## Application for a non-material amendment following a grant of planning permission

Proposed change of use and conversion of single-storey garage/workshop to two storey, two-bedroom holiday let including new dual pitch roof.

3/2024/0612

AMENDMENT TO PLANNING CONDITION 2

Projec	1 STRAITS LANE, READ, BURNLEY, BB12 7PE		Client	Roger Hindle Financial Services Ltd	
Drg	PROPOSED PLANS AND ELEVATIONS		draw	drawing	
			dat	05/12/23	2352-PR01E
			scale	A1	
				1:50

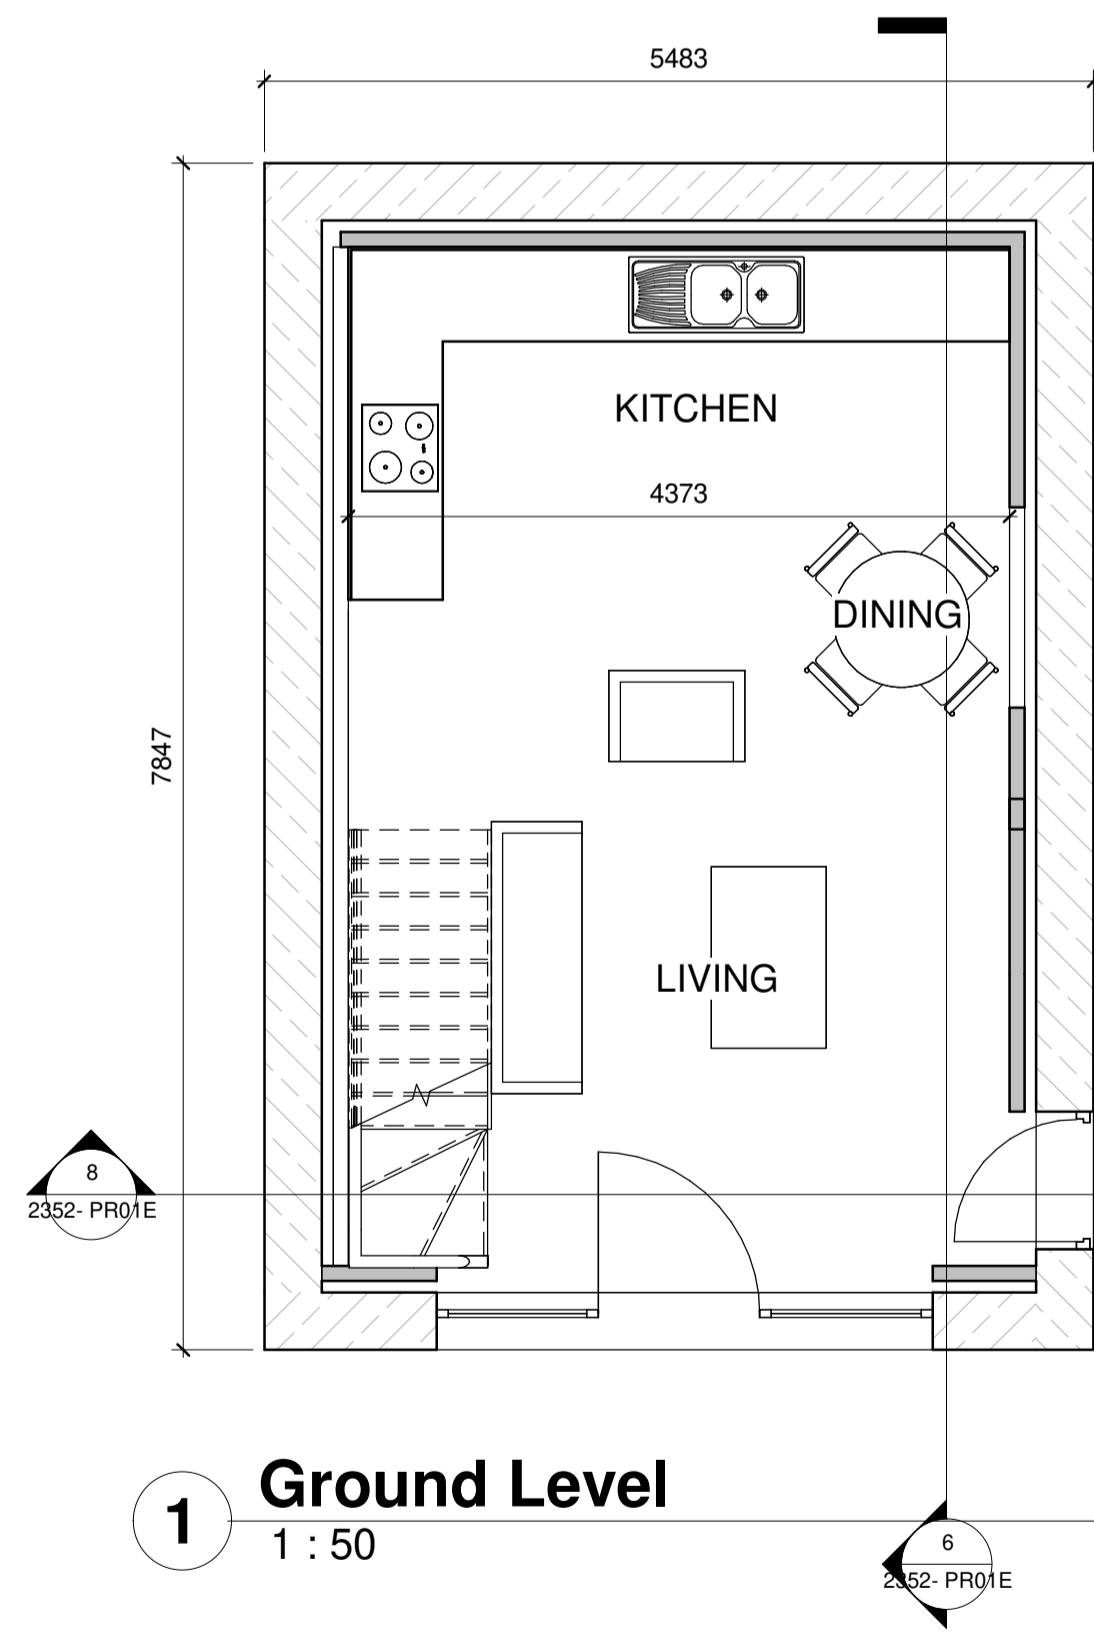
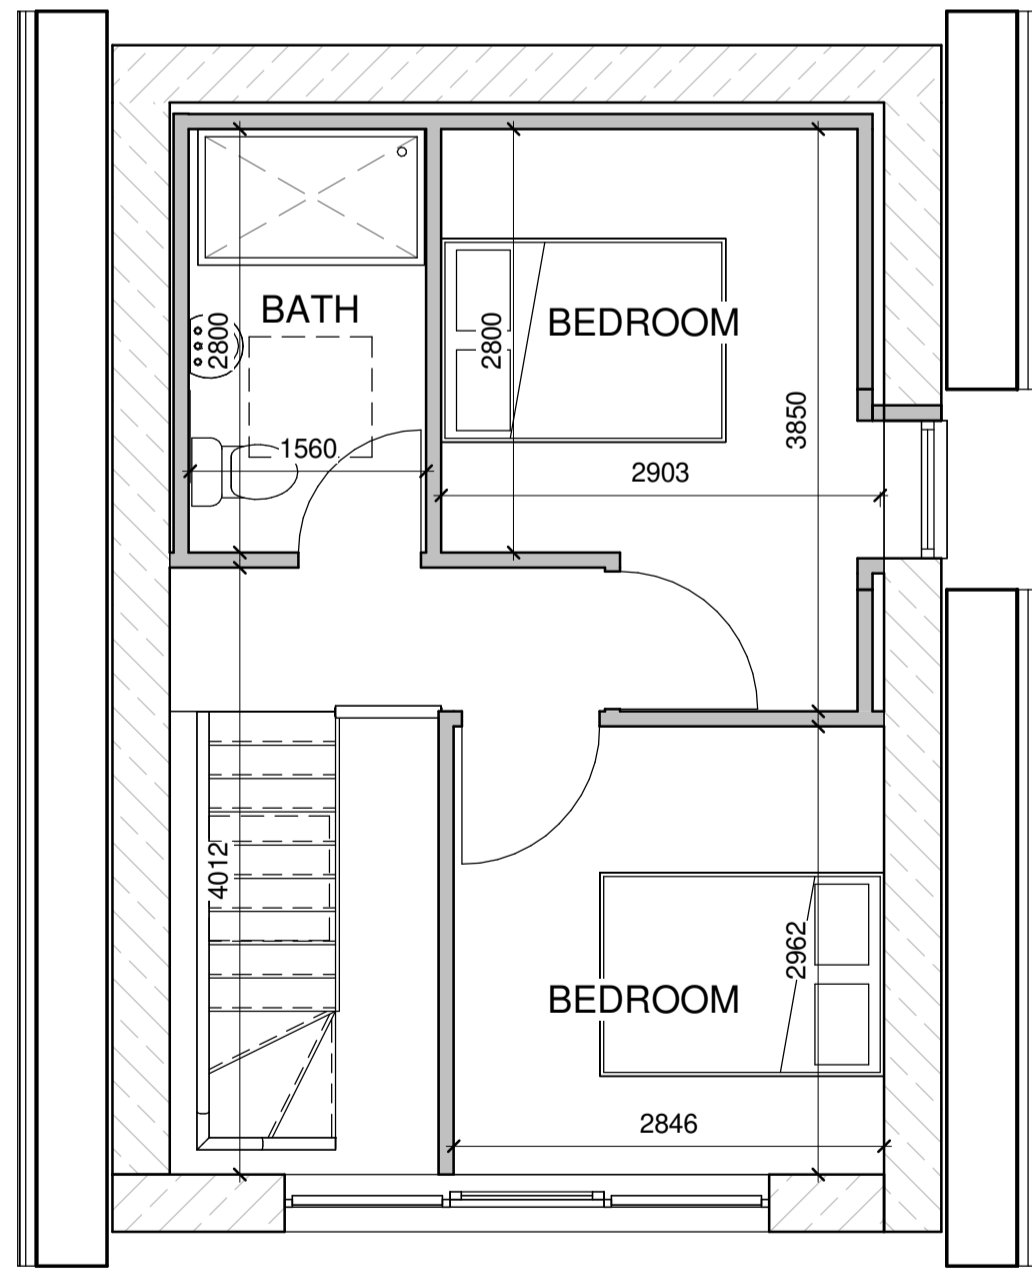
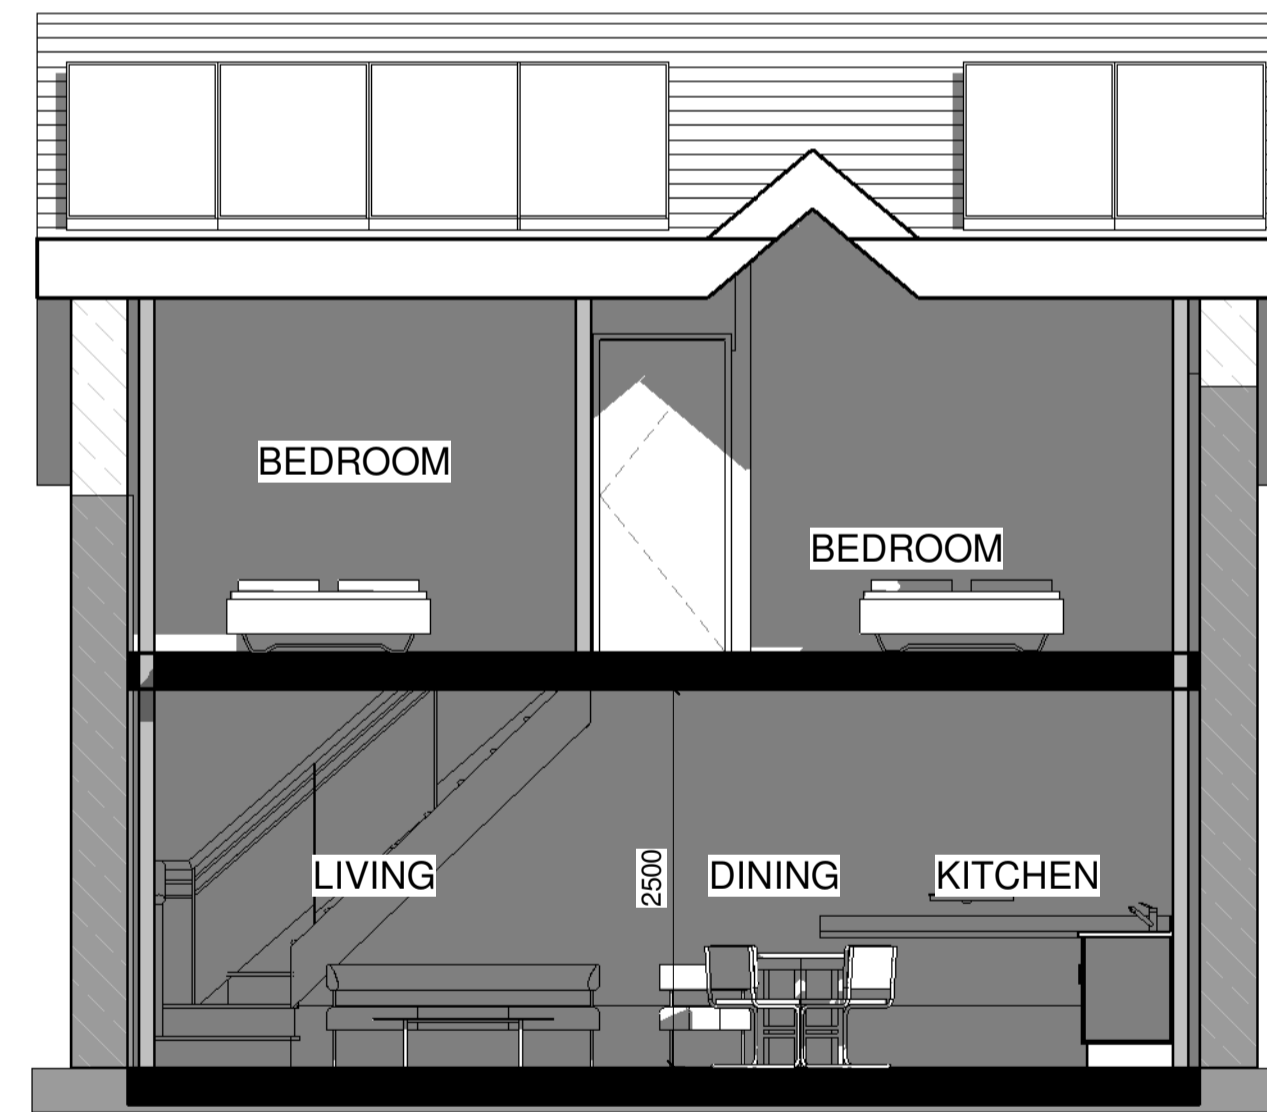
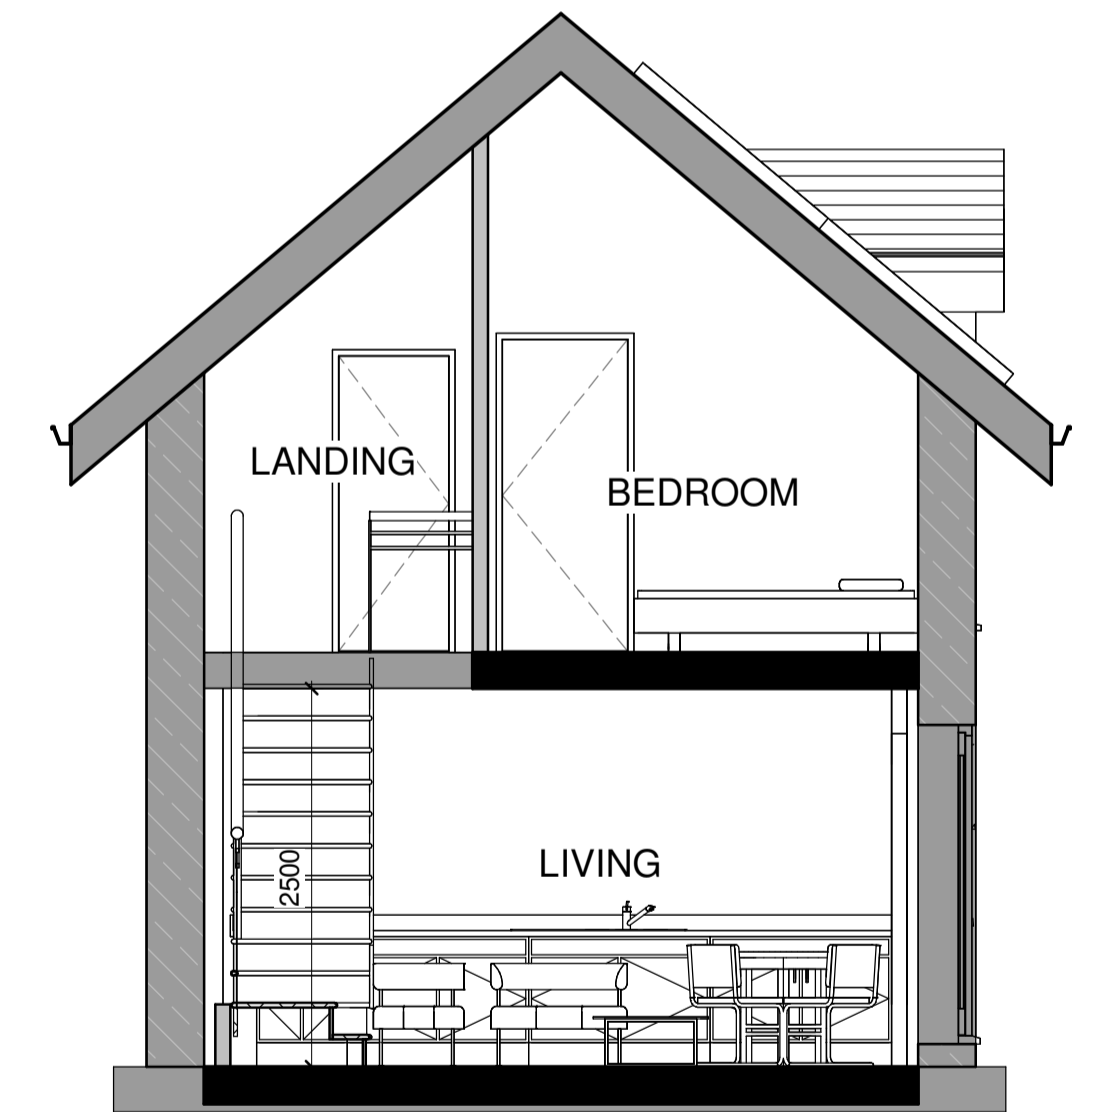
FOLLOWING A COST ANALYSIS FROM BUILDING CONTRACTOR QUOTATIONS AND A REVIEW FROM A STRUCTURAL ENGINEER, THE PLANS HAVE BEEN AMENDED TO MAKE THE SCHEME MORE VIABLE. FRONT AND SIDE BOARDING HAS BEEN REMOVED AND REPLACED WITH STONE TO MATCH THE LOCAL VERNACULAR ALONG WITH ADDING A SIDE ACCESS DOOR. THE STONE WILL SERVE AS A LONG LASTING AND COST EFFECTIVE MATERIAL CHOICE ALONG WITH A SAFER CONSTRUCTION MATERIAL RESISTING FIRE. GLAZING TO THE FRONT GABLE HAS BEEN REDUCED FOR BUILD PRATICALITY. Increase in roof height due to increase levels of insulation required to meet current building regulations, intro- of solar panels to provide a renewable energy source and fenestration changes and a wider gable dormer.

Proposed Elevations and Plans 2352-PR01 D
